CITY OF ALBUQUERQUE

June 15, 2016

**RE: Desert Sands Subdivision
Drainage Report, and Grading and Drainage Plan
Engineer's Stamp Date 4-27-2016 (File: N09D014)**

DESERT SANDS SUBDIVISION
GRADING & DRAINAGE PLAN

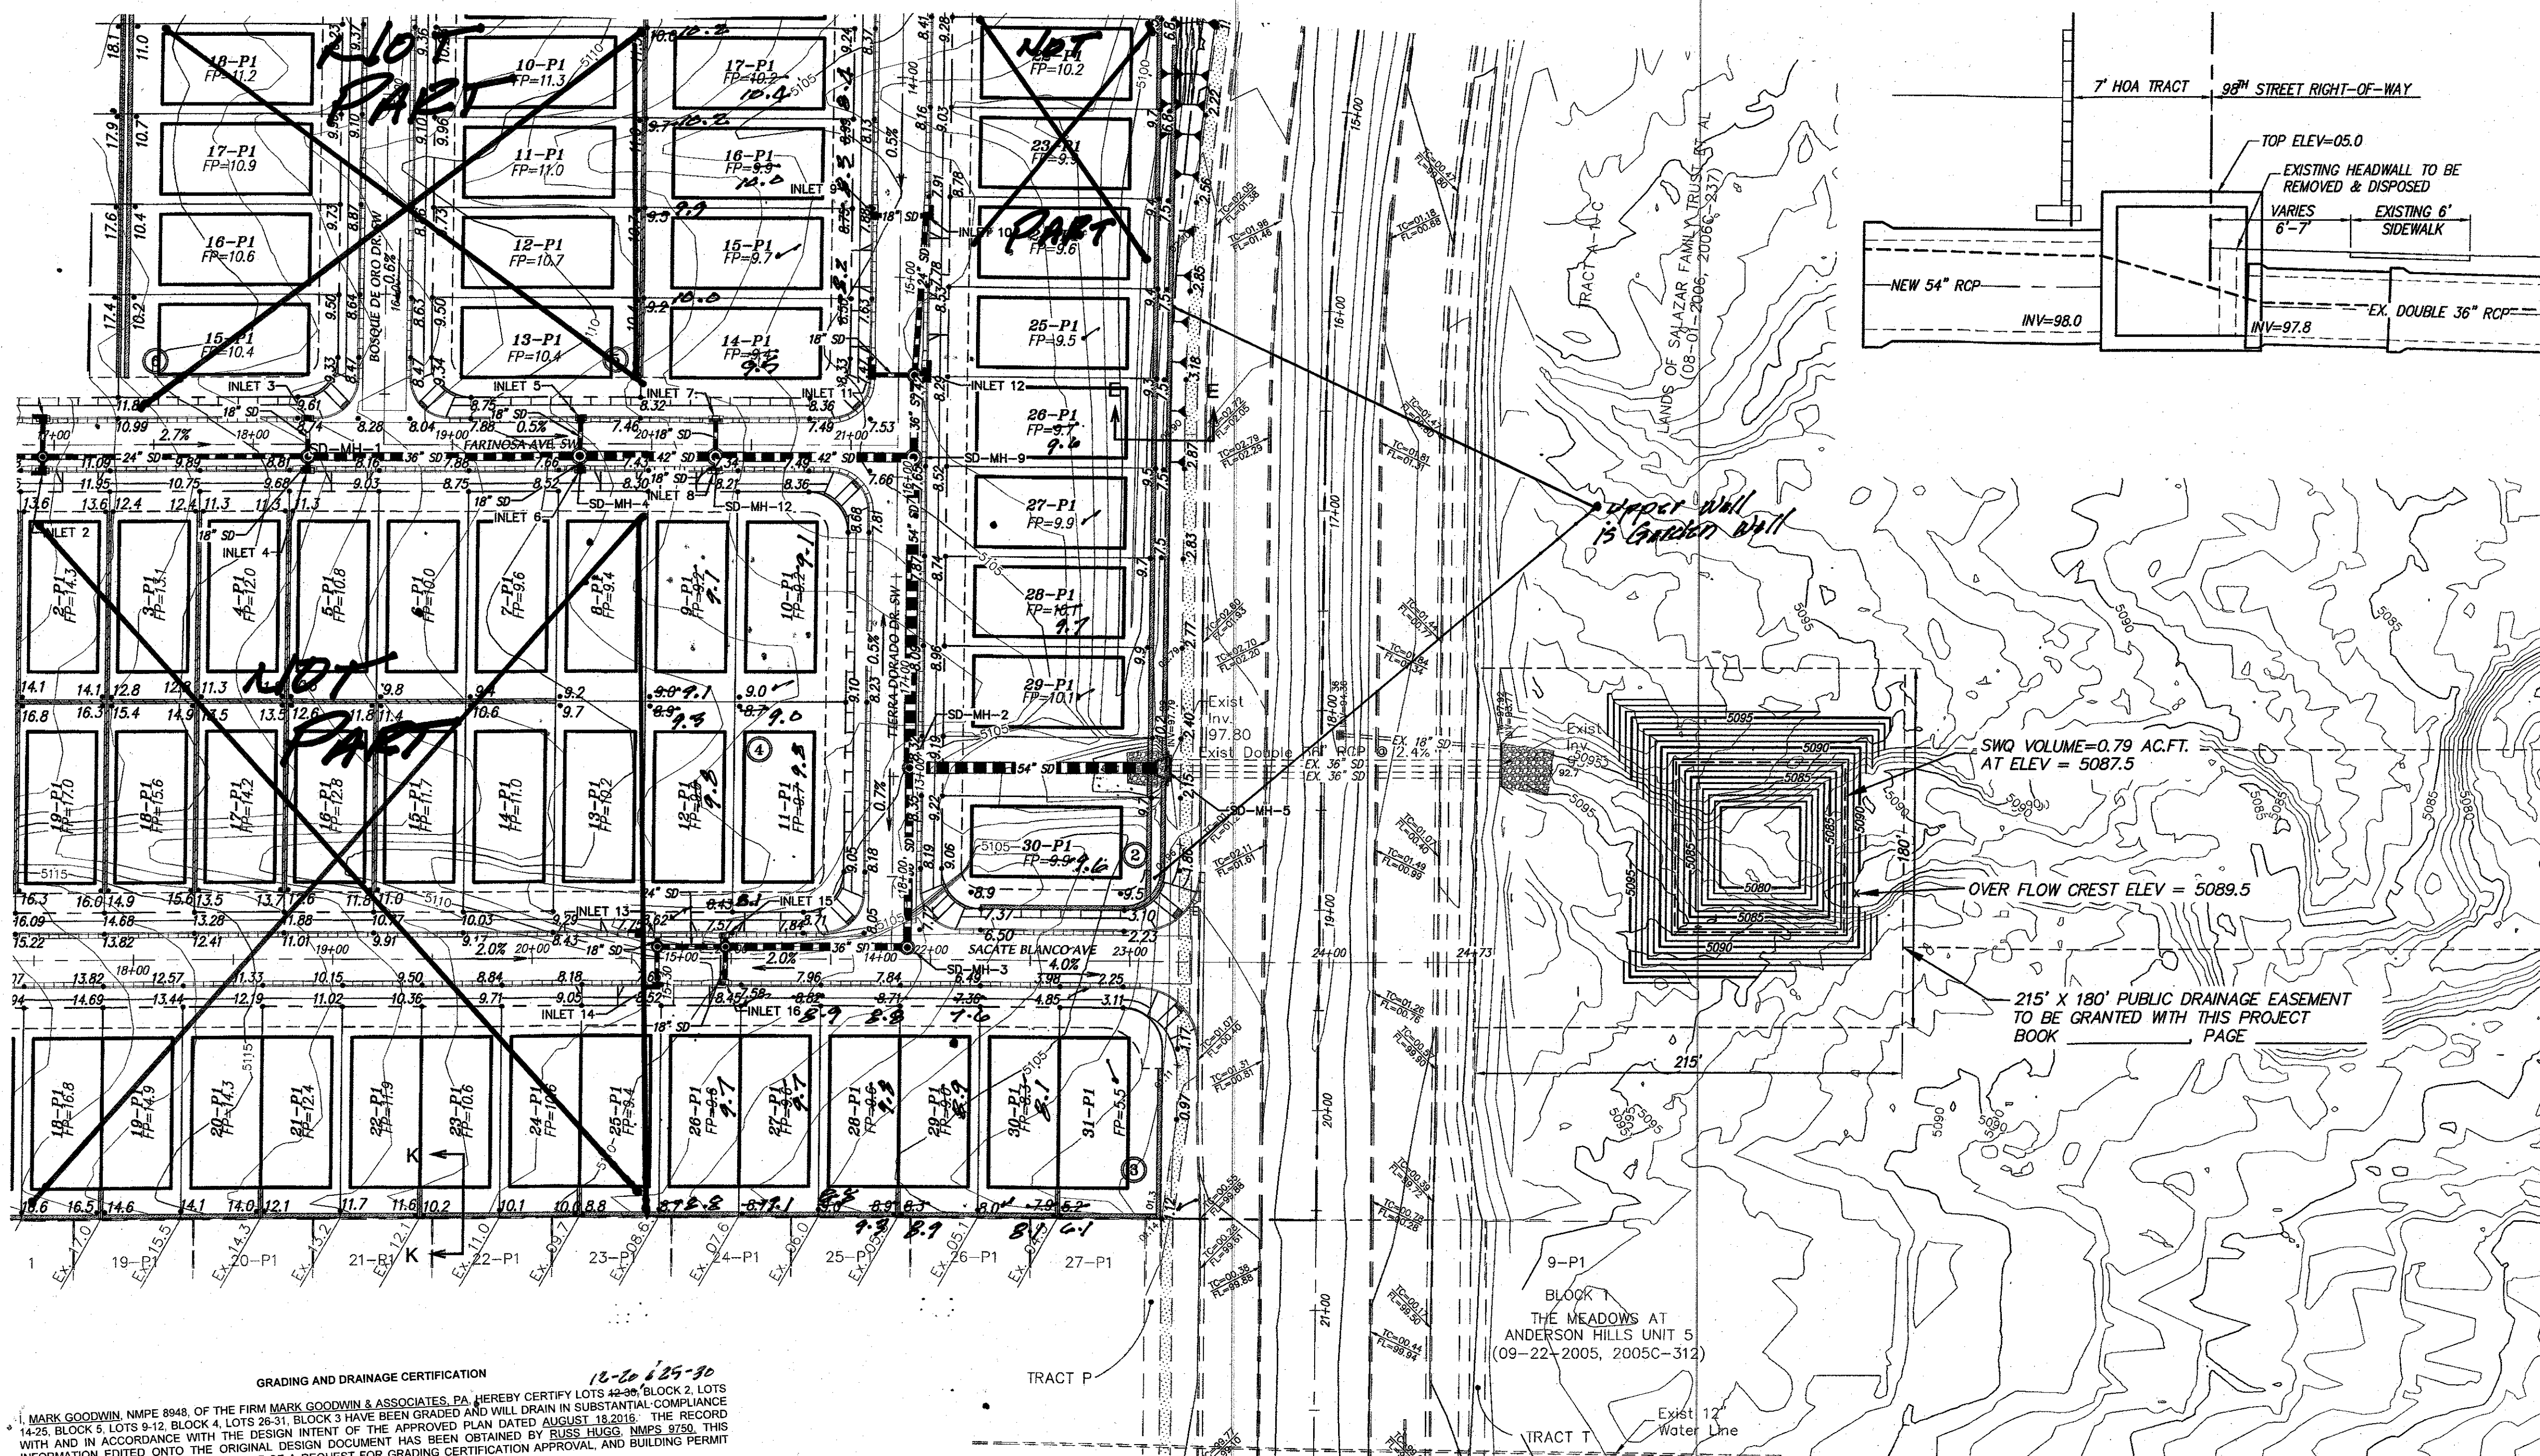
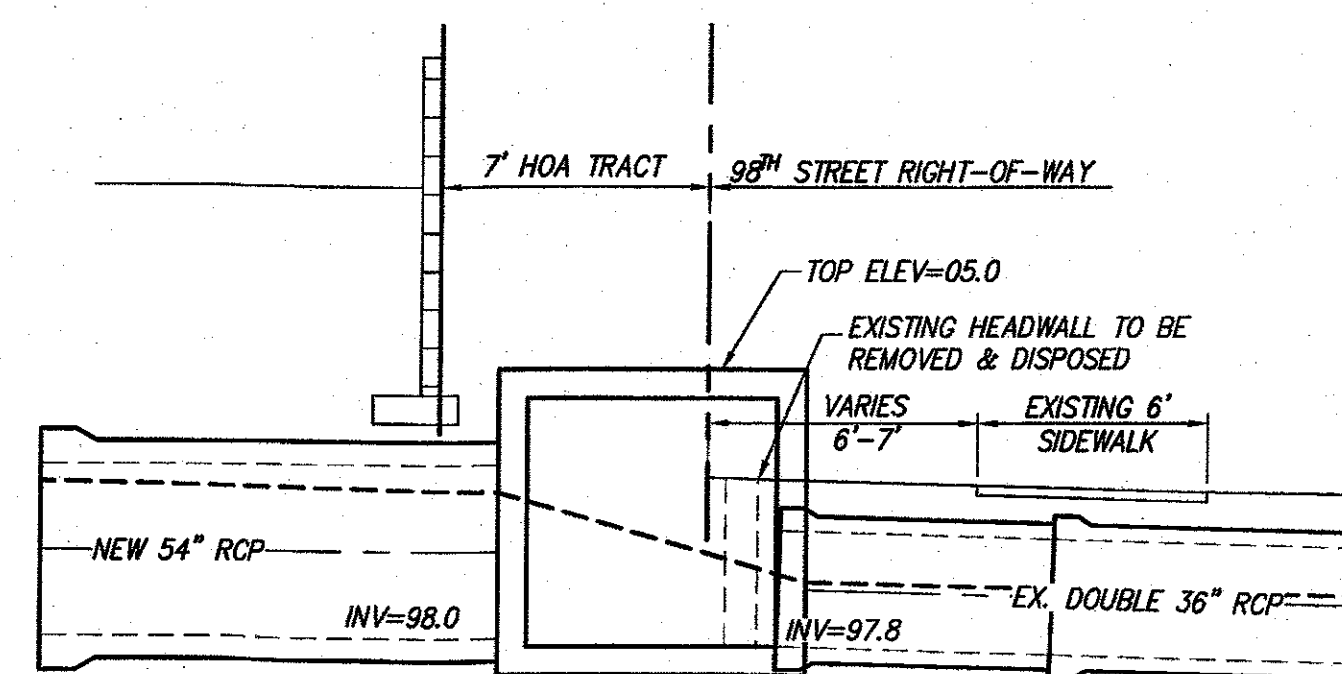
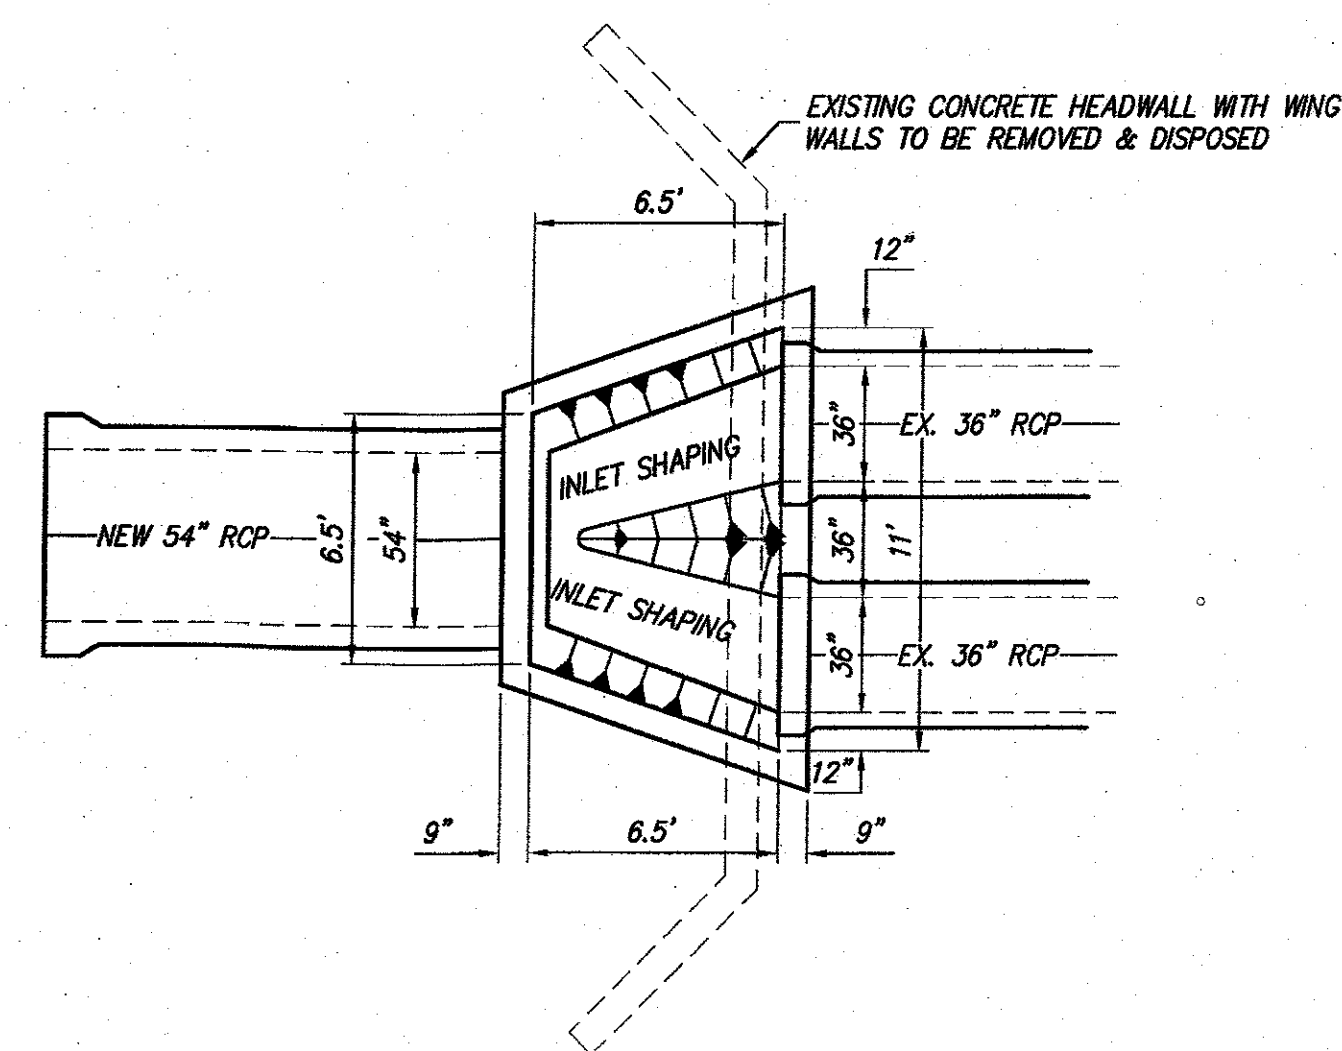
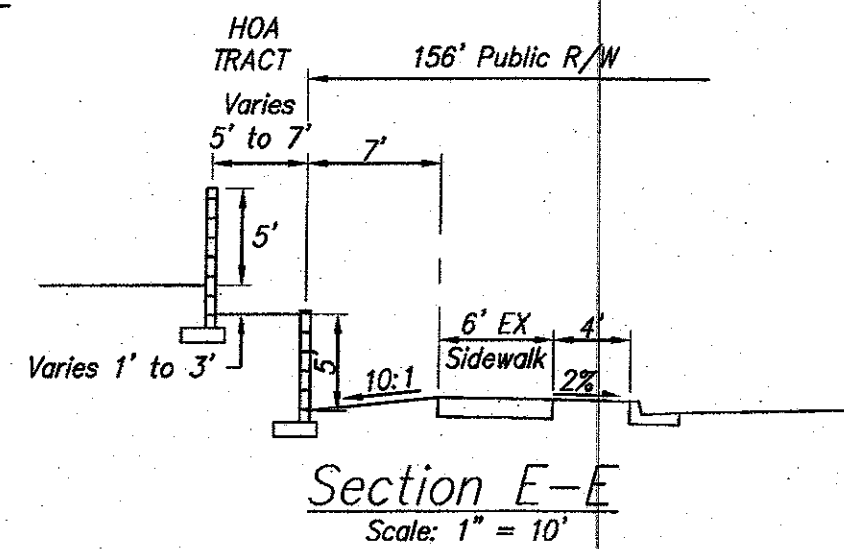
4. Provide Street Slopes on the Grading Plan
5. Provide a full size sheet of the Basin Map, showing legible street slopes.
6. NMDOT inlets cannot be used unless approved by DMD and City Engineer- use Single A with Dbl. wings in sump. Provide calculations. For single grate, use area of 3.84SF for orifice equation, and length of 10.8 ft for wier. For wier calculations, can use both wings.

8. Raise the pad elevation of Lot 11-P1 to be 8.7 ft.
9. Move inlets 1 and 2 further upstream so that EGL is lowered.
10. On the Civildesign output, handwrite in the sidebar the inlet # and grate el next to the corresponding station. Do the same for MHs and Rim El. (the construction plans are too small to compare the HGL). Also, label the output so that it corresponds to the construction drawing, ie. Sacate Blanco.

14. The SD trunk lines need to be moved so that the Curb and Gutter is outside of the trench prism. Laterals should be used to connect the inlets to a MH along the main trunk line.

- a. Show road slopes
 - b. Retaining wall along southern boundary is shown right up against the existing screen walls and there may be constructability issues. Provide a section cut along the southern boundary.

- c. Spot el= 39.46 between 60-P1 and 59-P1 is low.
 - d. Provide FL EL. along Pauza Dr
 - e. Section B-B implies runoff flows along sidewall, as opposed to a parallel swale

- f. Lot 1-P1: how will lot discharge? Low point seems to be at end of retaining wall. Will there be a screen wall around the corner? Runoff should not discharge should curb ramp.

- g. Provide elevations between Lots 1-P1 and 2-P1
 - h. North of Lot 16-P1, elev along Ret. Wall is 43.09. Typo?
 - i. Provide Elevations north of Lot 17-P1

- j. South side of Colobel, North of Lots 1 thru 16: How does the area between the Sidewalk and retaining wall drain? Provide proposed contours. It seems that the swale within the landscape buffer should be used to collect these flows.

- k. On south side of Colobel, east of Pauza, the swale in the landscape buffer should be used. The swale should be able to discharge to the SW culvert downstream with a cut in the channel.

- l. Show the landscape buffer swale in the section cuts.
 - m. Provide a section of Colobel (showing existing and proposed construction) and existing FL EL along the North side of Colobel to show that it is superelevated, and that a Waterblock is not needed at the Pauza Drive and Colobel intersection. Also, more FL. Elevations on Pauza Dr, south of Coloble should be shown.

- n.
 - o. Each lot should have a unique lot number. Many have the same number.
 - p. Is this a phased project? If so, an interim grading plan is required for each phase, showing how the drainage for the undeveloped areas are to discharge.

- q. What is intended for Tract B? show proposed contours.
